Corrections Narrative

DuBois Addition – 2955 74th Ave SE

3.7.23

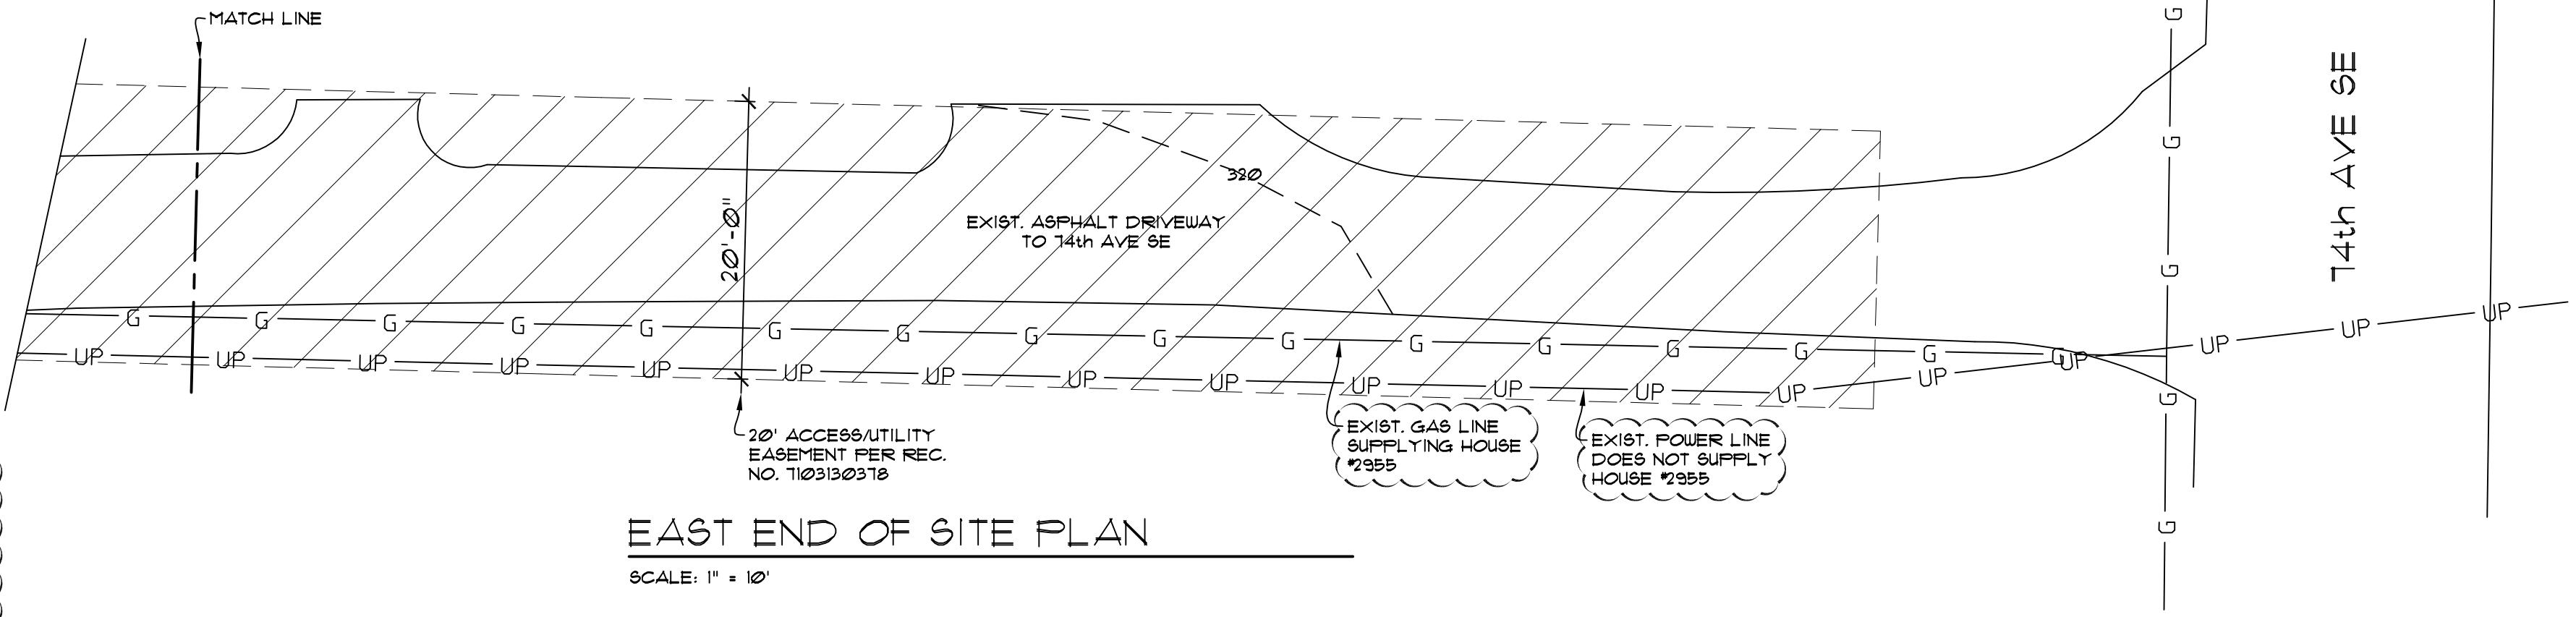
Lot coverage/hardscape:

We have located a previously approved site plan (permit# 0705-137) for this property that is consistent with our new survey and current site plan regarding location of all existing lot coverage and hardscape areas (building perimeter/roof overhang, driveway layout, shed, rear deck/patio, and walkways). We believe that this establishes the site's lot coverage and hardscape as legally non-confirming.

VICINITY MAP

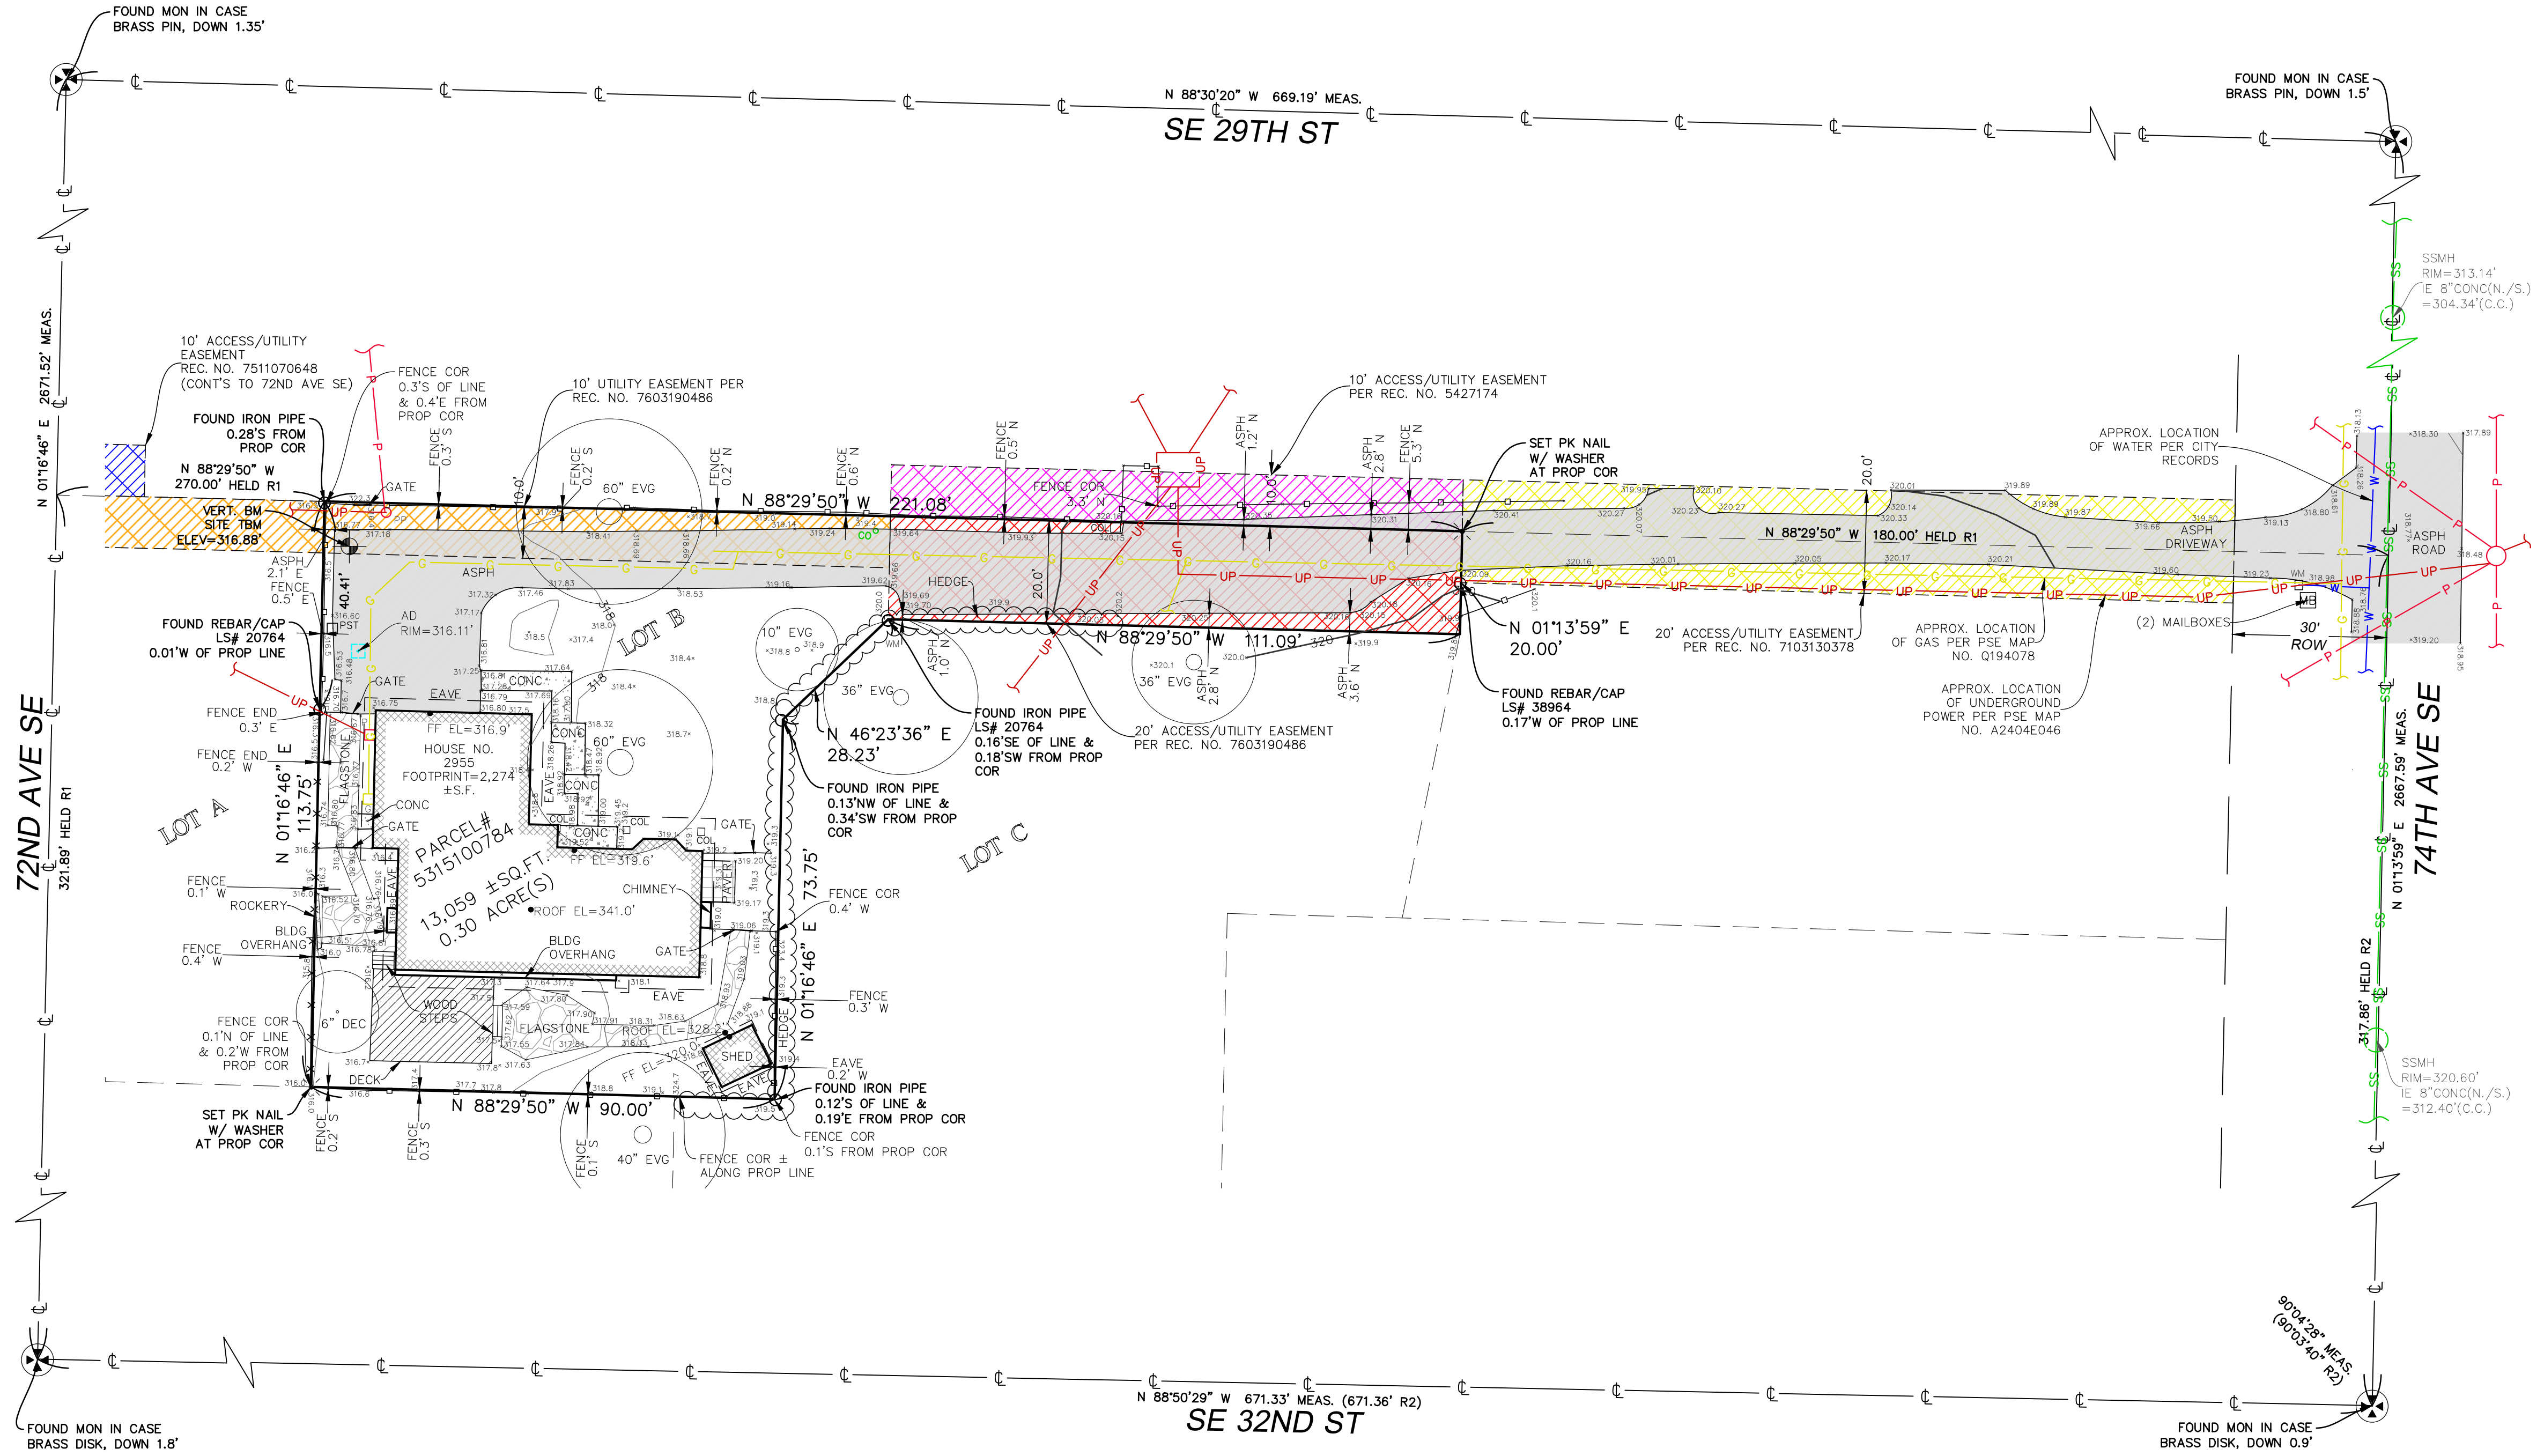
EASEMENT / WATER SUPPLY LINE

The survey of record has been updated to include easement information for the water supply line path to 72nd. Additional information regarding this easement has also been submitted, along with confirmation from Terrane (surveyor) that the subject site benefits from this easement. We have also added a new Water Line Plan (sheet A0.5) to supplement our site plan.

LEGALLY NON CONFORMING CALCULATIONS
 SCALE: 1" = 20'

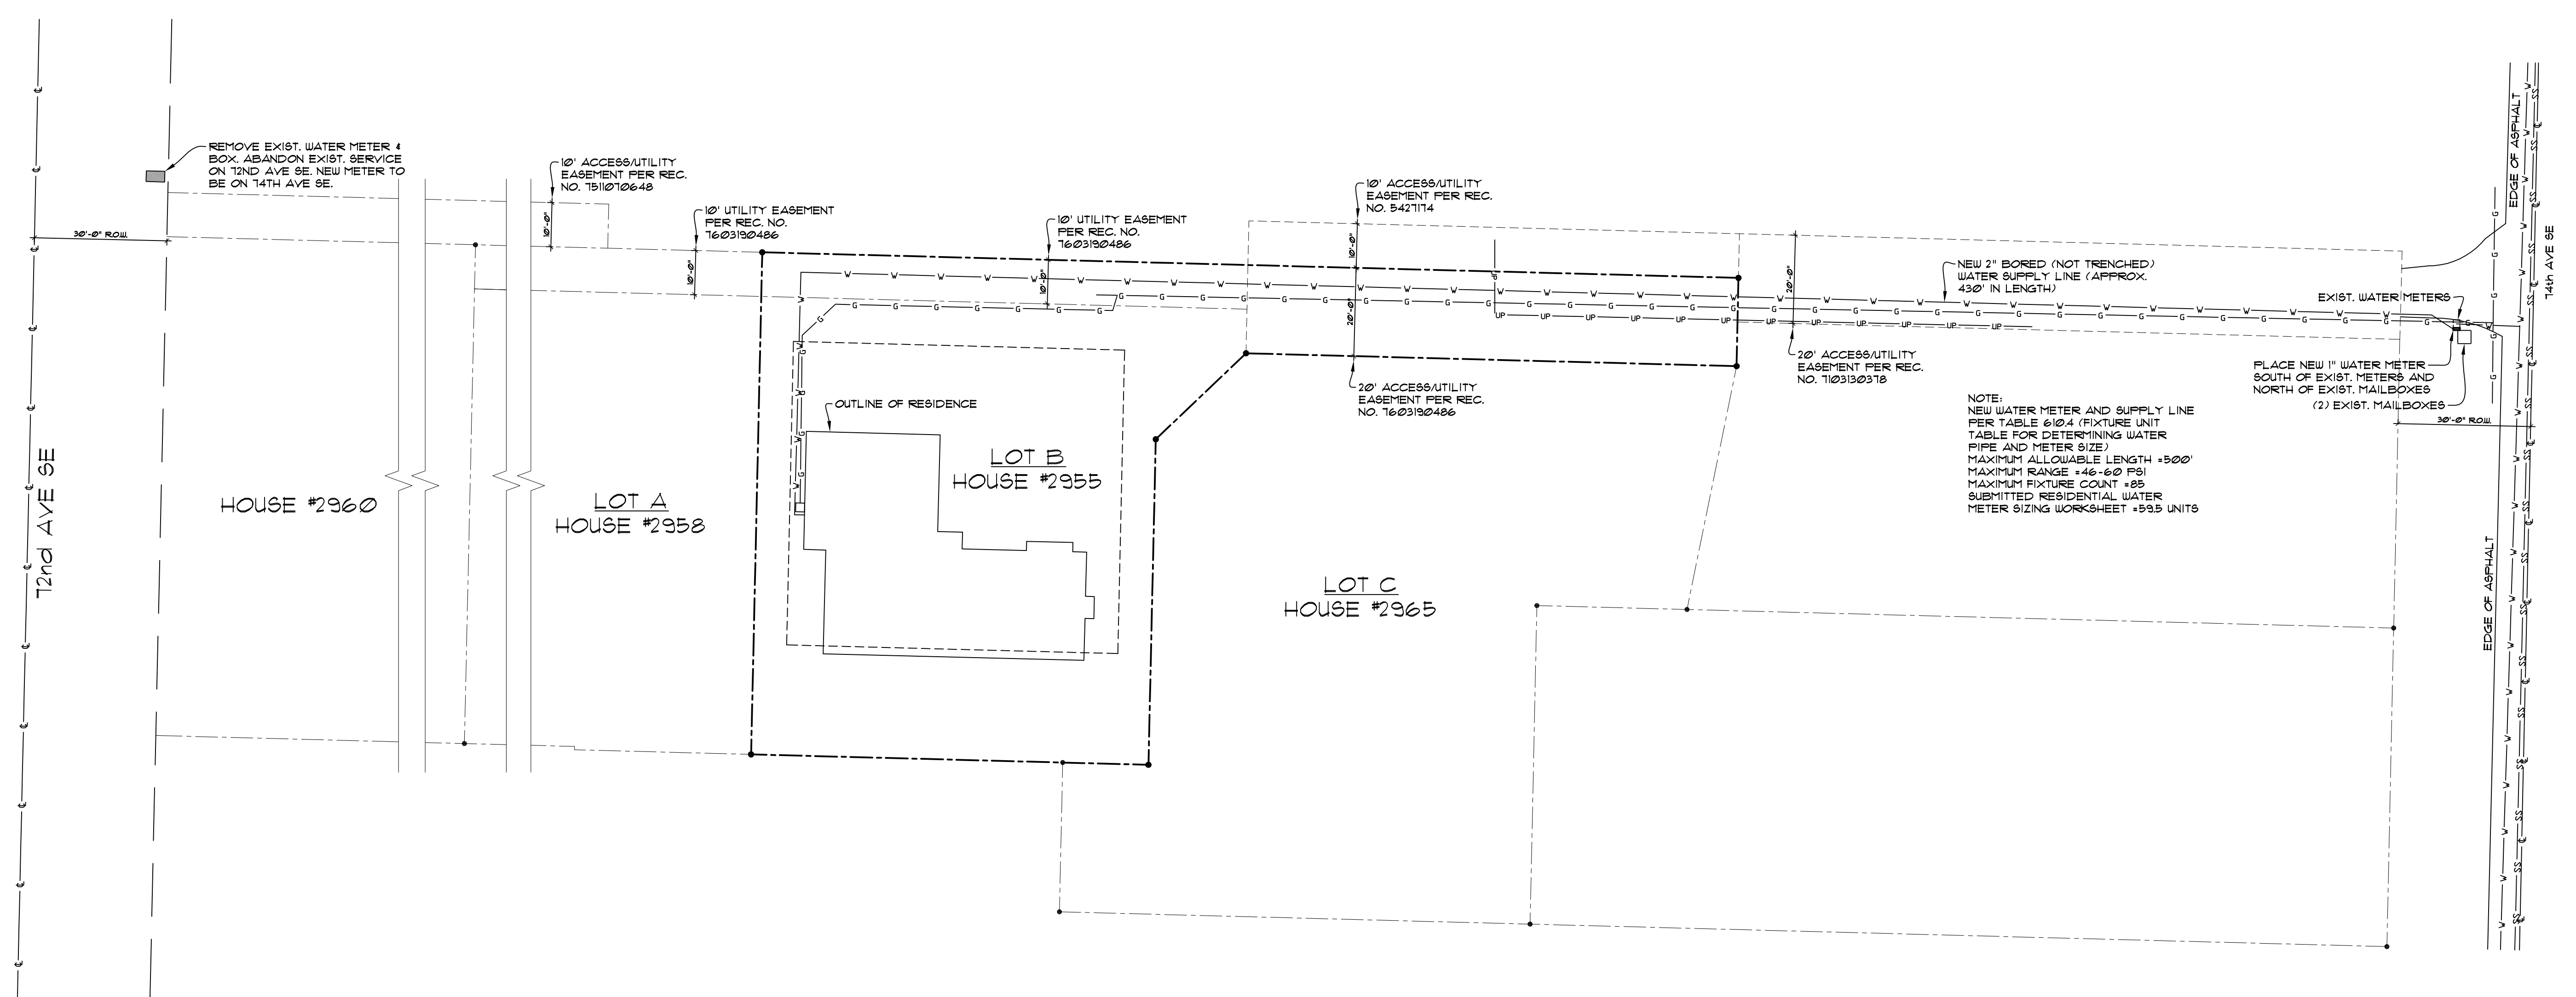
Altering of exterior walls:

We have added a diagram to new sheet A0.5 to show that we are not structurally altering over 40% of the existing perimeter walls.
